CITY OF ALBUQUERQUE

December 23, 2021

**RE: 615 Iron Ave SW
615 Iron Ave SW
Grading and Drainage Plan
Engineer's Stamp Date: 11/8/2021
Hydrology File: K14D225**

SHEET No. **C-1**

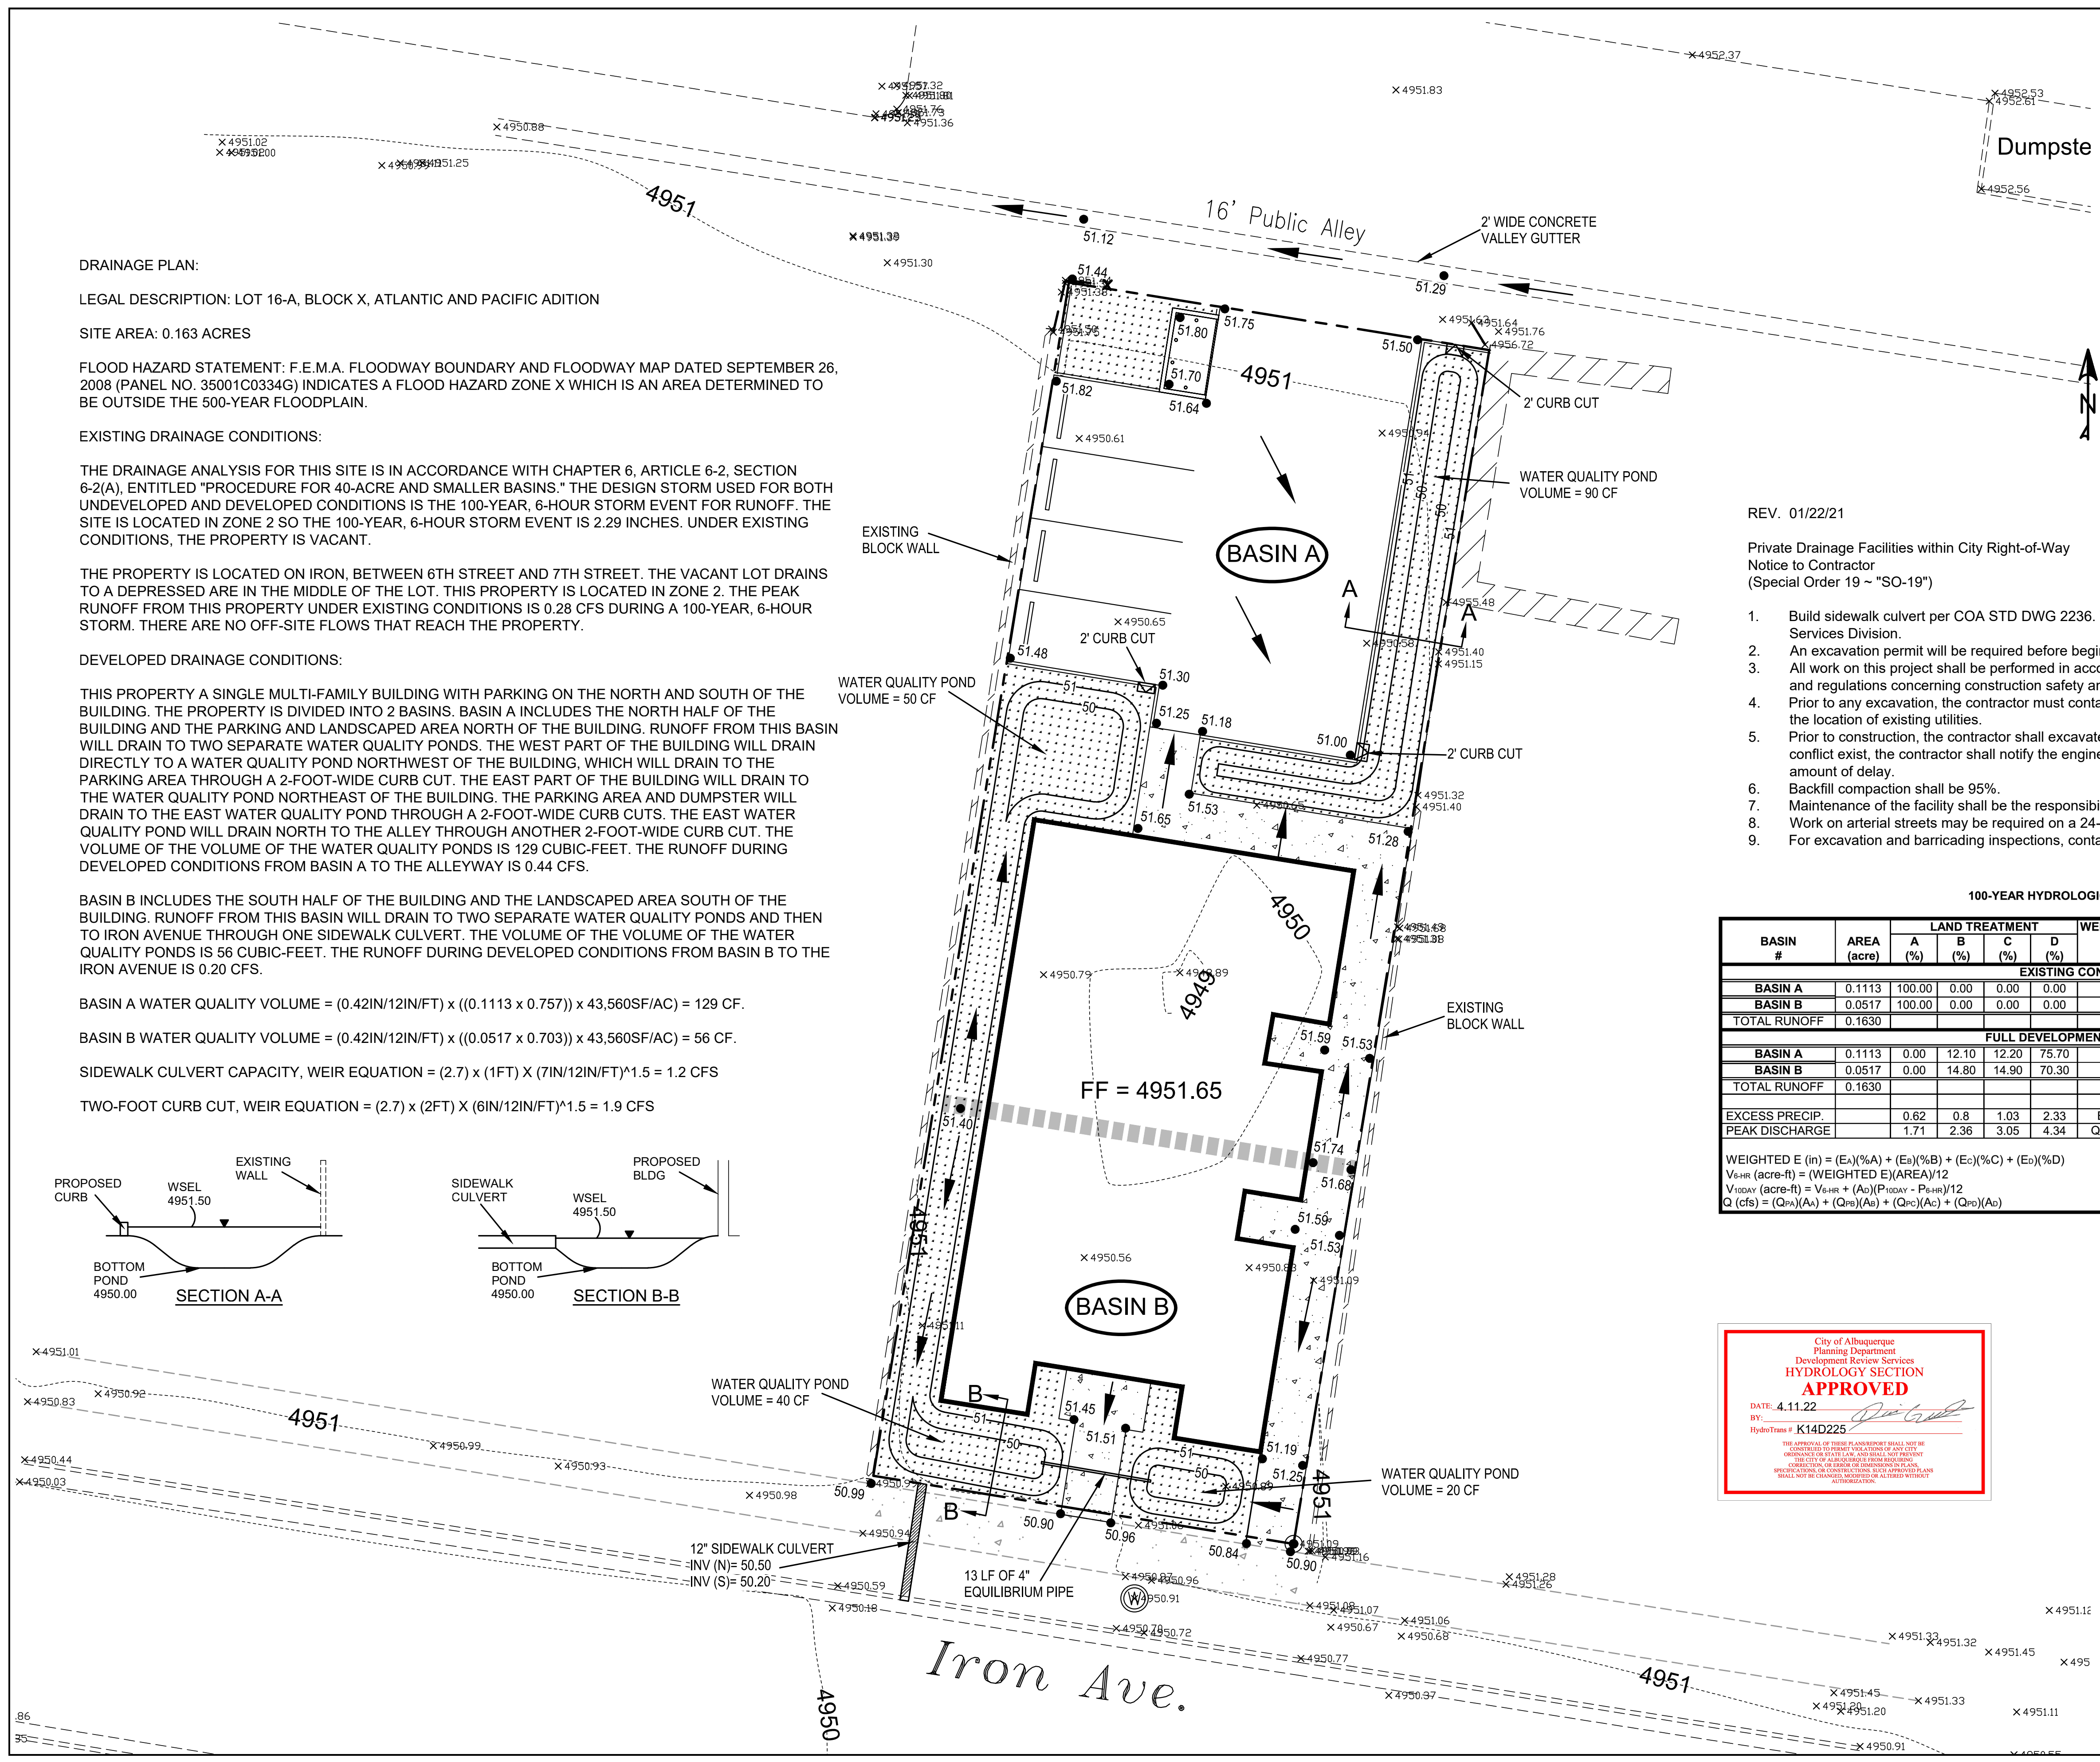
SHEET C-1

1. Show adjacent lots and street/alley grades to show how grades tie in and show how the site will not drain into adjacent sites.
2. Provide a drainage covenant for all ponds.
3. Please include
4. Basin A
 - a. Please provide survey of the alley and show how this will tie into the alley with the proposed grades.
 - b. There is no curb, please show how this will discharge into the alley.
 - i. Curb cut shown is not applicable.
 - c. Please provide a detail of the proposed pond and elevations of how it will drain north into the alley. Provide spot elevations at the north and south of pond to show this drainage. Show the water quality level to be retained.
 - d. What is preventing stormwater to drain toward the building here?

5. Basin B
 - a. Please provide Water Quality Volume for this basin as well.
 - b. For the outlet please show how this will be provided. See standard detail 2235.
 - c. You can move the parking spots east a few feet to fit a pond in this landscape area and adjust grades to allow drainage to enter into the pond.
 - d. The driveway will need to be adjusted and perhaps maintain the current drive.
 - i. There is a meter box in the middle of the proposed drive which will not be acceptable. Please check with the Water Authority for their comment.
 - e. The sidewalk is in poor condition and will need replacement and the driveway will need to be paved. Check with Transportation for their requirements.
6. Please review and ensure no ponding takes place and drainage is away from the building.

7. Please utilize current terminology. First Flush is no longer utilized. Water Quality Volume is appropriate and in agreement with the current DPM

Please utilize new terminology. "Water Quality Volume"
